THE RESERVE AT CORRAL BLUFFS FILING NO. 3

FILE NO. SF-207

Final Plat_V1.pdf Markup Summary

THE RESERVE AT CORRAL BLUFFS FILING NO. 3

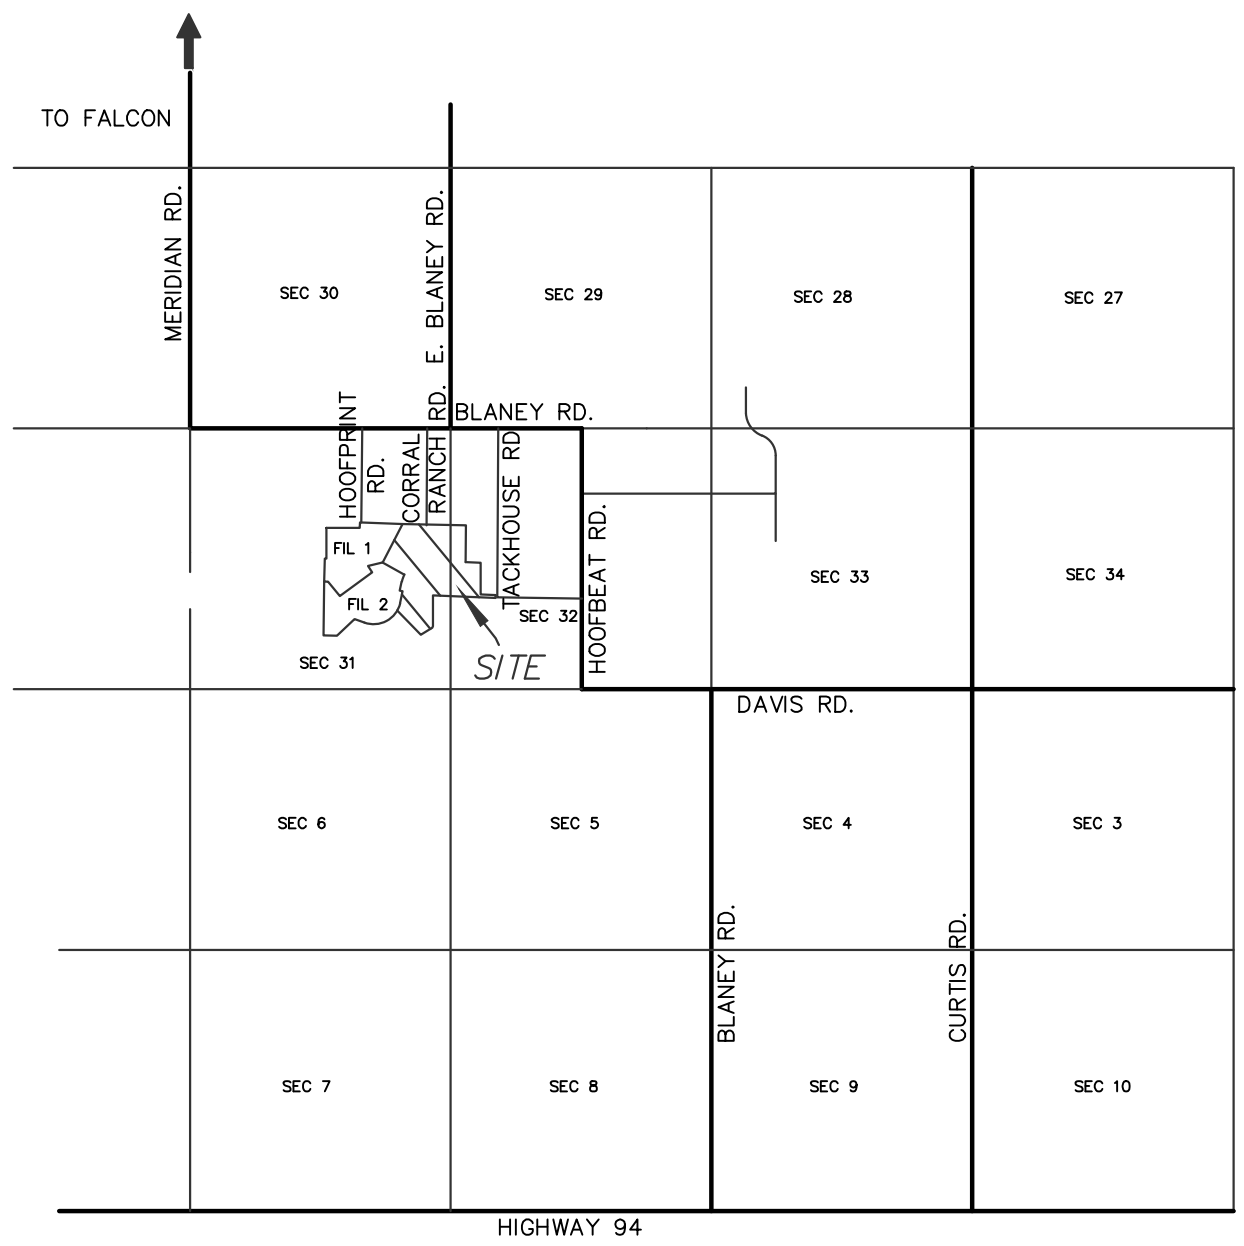
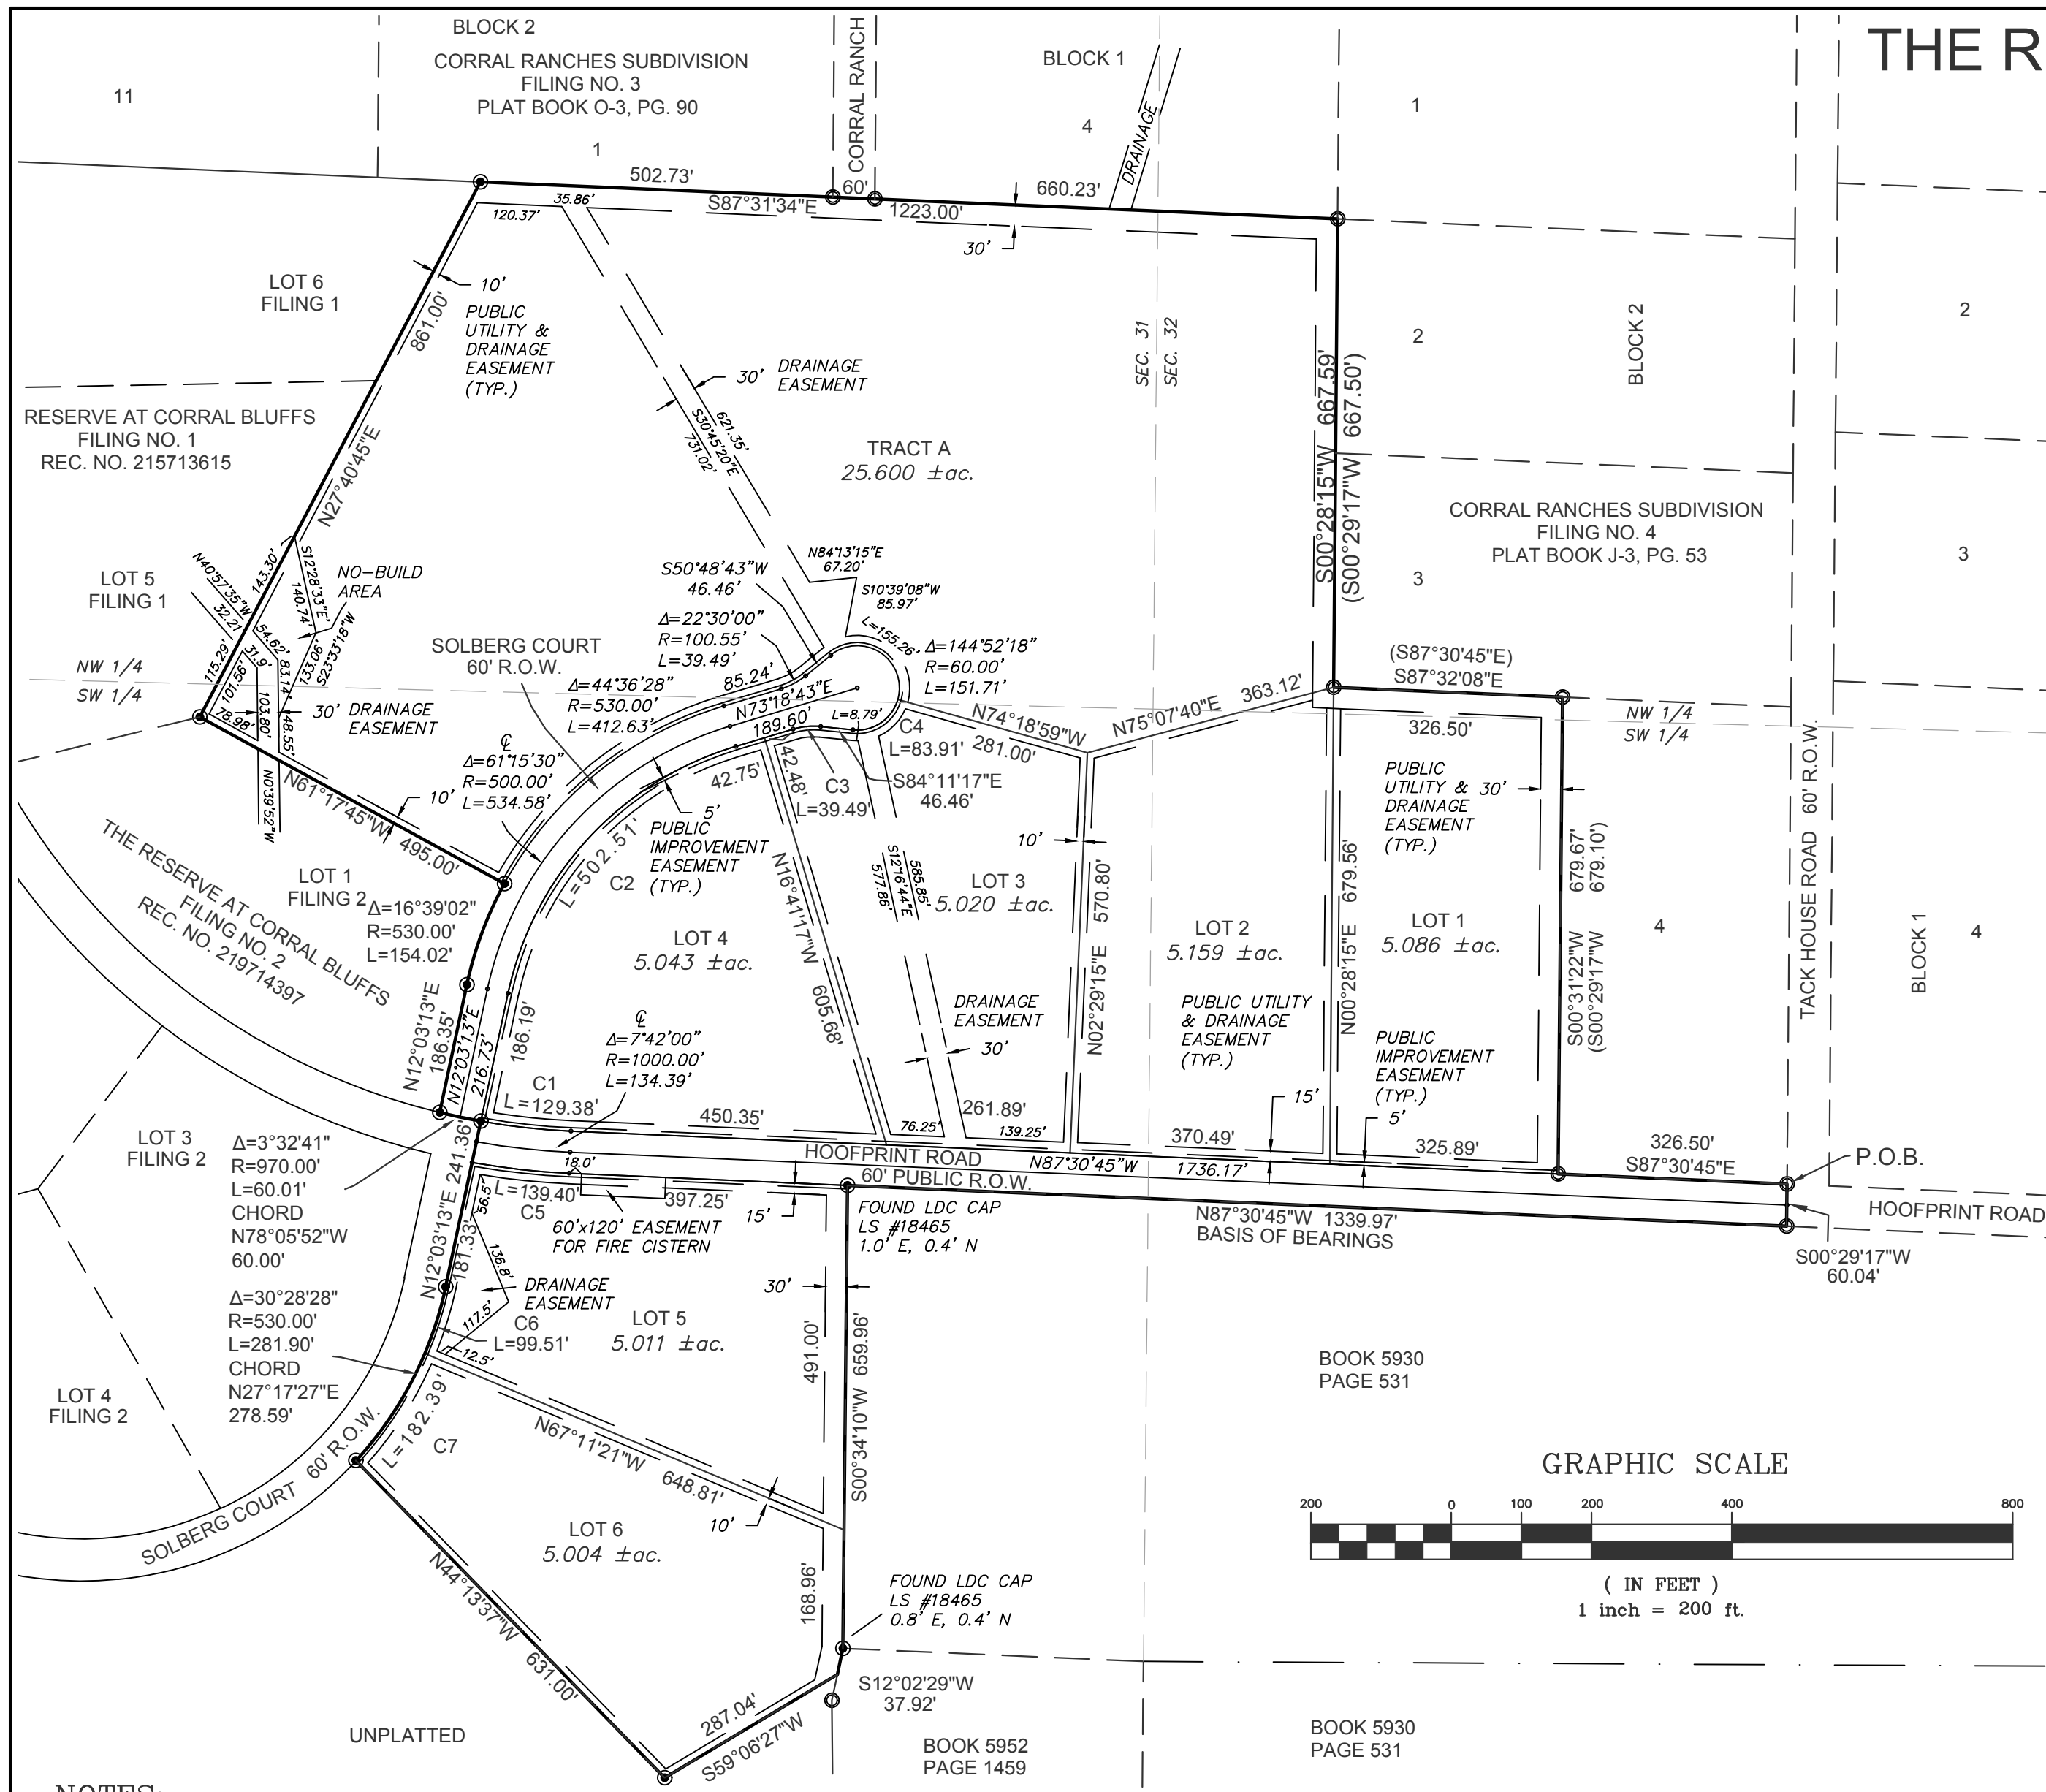
Please revise to include public improvements as shown on the road cross-section in the construction documents.

Revise to Public Improvement Easement or provide a 5' Public improvement easement per the standard El Paso County rural gravel road section (detail SD_2-10). See snippet below.

Add the following plat note:
Lot 5 and Tract A of this property is subject to a Private Detention Basin/Stormwater Quality BMP Maintenance Agreement and Easement as recorded at Reception No. _____ of the records of El Paso County. The _____ HOA (or Owner or District) is responsible for maintenance of the subject drainage facilities.

Previous comment not addressed - verify information, soils and geology report indicate impacts to Lots 1, 2, 3, 4, 6, and tract A, and areas of ponding water should be no-build areas and should be depicted

Indicate the ROW for Hoofprint Road

Please revise to include public improvements as shown on the road cross-section in the construction documents.

If these are Type 3 cluster boxes, update plans and plat to meet ECM Chapter 4 Section 4.4.5.E for mailbox placement.
 "Type 3 mailbox and the pullout for the mailbox shall be located within the ROW but outside the roadway clearzone.

verify information, soils and geology report indicate impacts to Lots 1, 2, 3, 4, 6, and tract A, and areas of ponding water should be no-build areas
